# WOODMOOR WATER & SANITATION DISTRICT NO. 1

# WOODMOOR WELL NO. 22

## SWMP, GRADING AND EROSION CONTROL PLAN

MARCH 2024

WELL NO. 22 TRANSMISSION LINE PLAN

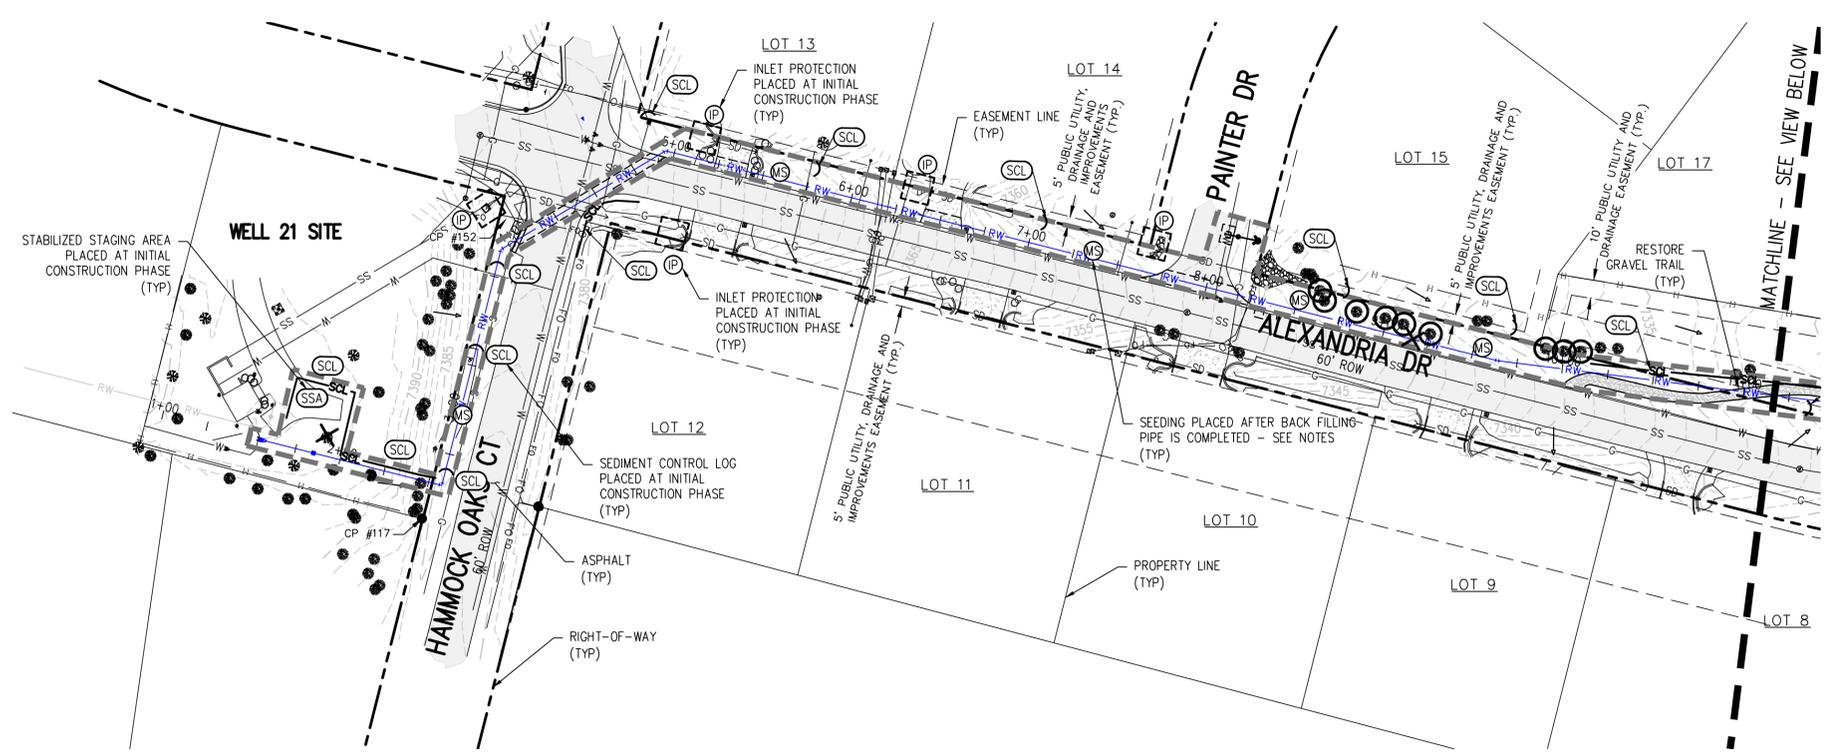
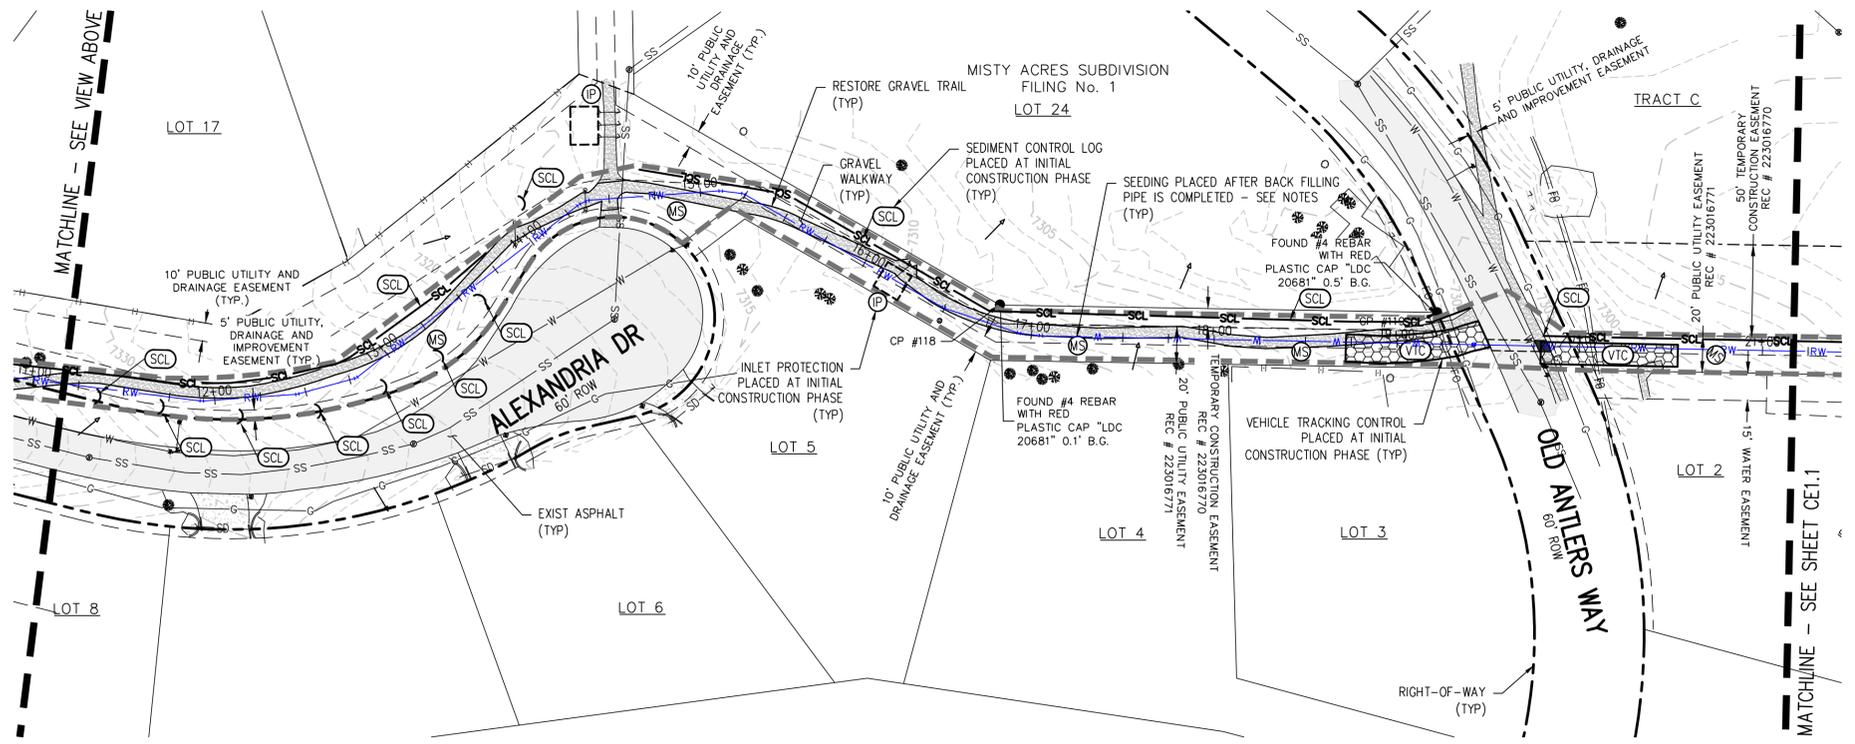
Item 1. Add Qualified Stormwater Manager and Contractor Information to cover/title sheet. If unknown, add a placeholder to be updated prior to the pre-construction meeting:

Address SWMP Checklist Items 10 & 14.
